Transport
for NSW

TfNSW Reference: SYD21/00890/02
DPIE Reference: SSD-24452965

EXHIBITION OF EIS – THE EELS CENTRE OF EXCELLENCE AND COMMUNITY CENTRE – 8 MEMORIAL AVENUE, KELLYVILLE

Attachment A

Figure 2.5 Windsor/Fairway AM Peak

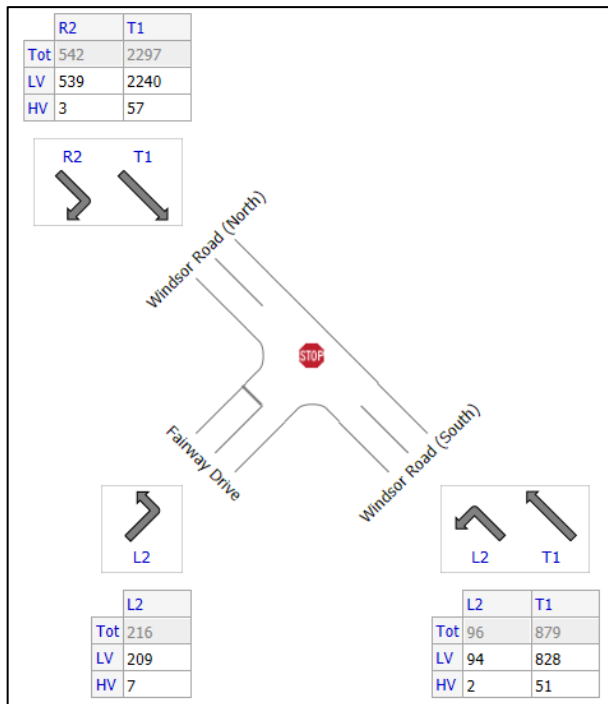
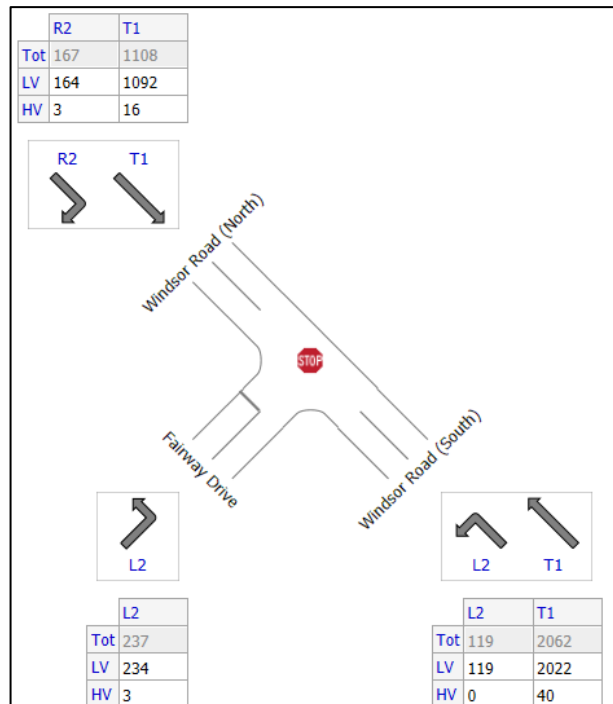
1. It is noted the traffic impact at the intersection of Fairway Drive/Windsor Road has only been modelled for existing scenario. TfNSW has concerns regarding the impact at the intersection as a result of the proposed development and how the impact can be mitigated to maintain existing level of service. TfNSW requests impact at this intersection to be investigated for both existing and future years scenario with and without development. The proponent is to investigate alternative options to mitigate any impact (if required).

The Sidra outputs should also be included in the traffic report.

Figure 5.1 Anticipated Traffic Distributions

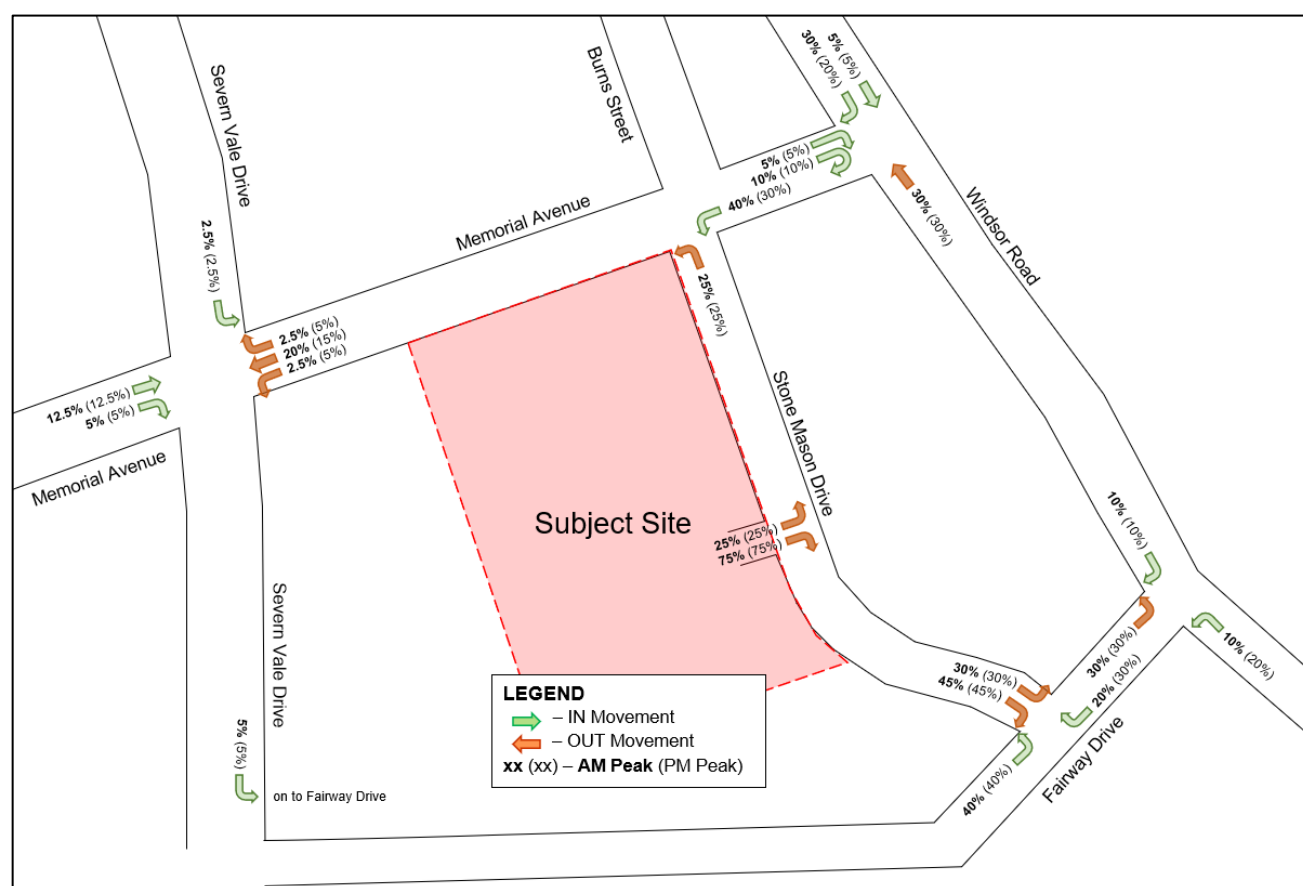
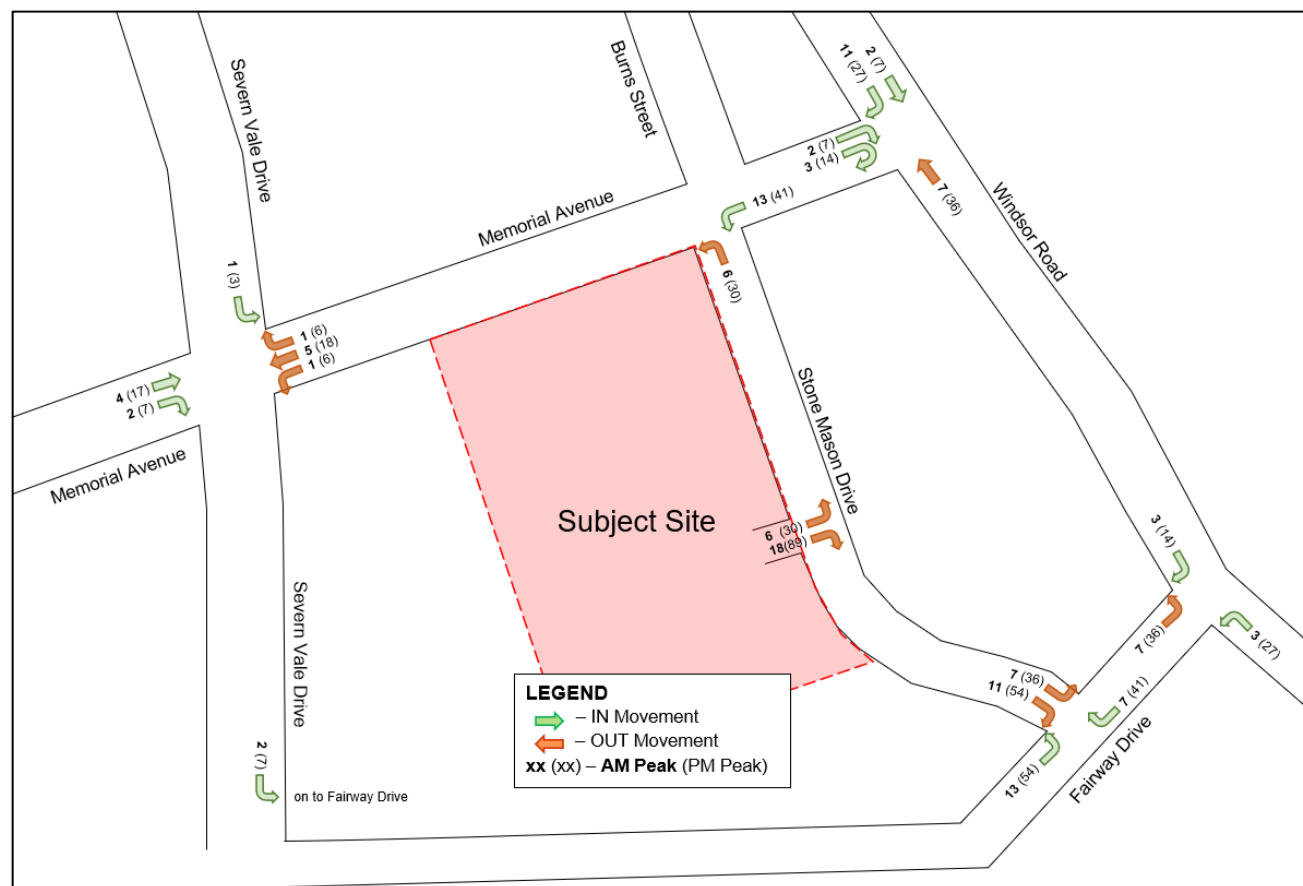
5. TfNSW requests the proponent clarify the U-turn movement at Memorial Rd/Windsor Road intersection (see Figures 5.1 and 5.2 in the Traffic Impact Assessment Report). U-turn movements at signalised intersections are not permitted in NSW unless signposted otherwise. This movement is not supported and should not be accounted for in determining the traffic distribution to the site.
6. The swept paths clearly show requirement for traffic management at Windsor Rd/Fairway Drive and access to Stone Mason Drive (not possible) and possible requirement for Memorial Av/Windsor Rd (19M SEMI and 12.5 HRV). This is a concern and may not be supported.
7. The proponent is to liaise with the Traffic Management Committee regarding any proposed traffic management proposals on event days to mitigate impacts to Memorial Ave and Windsor Road.
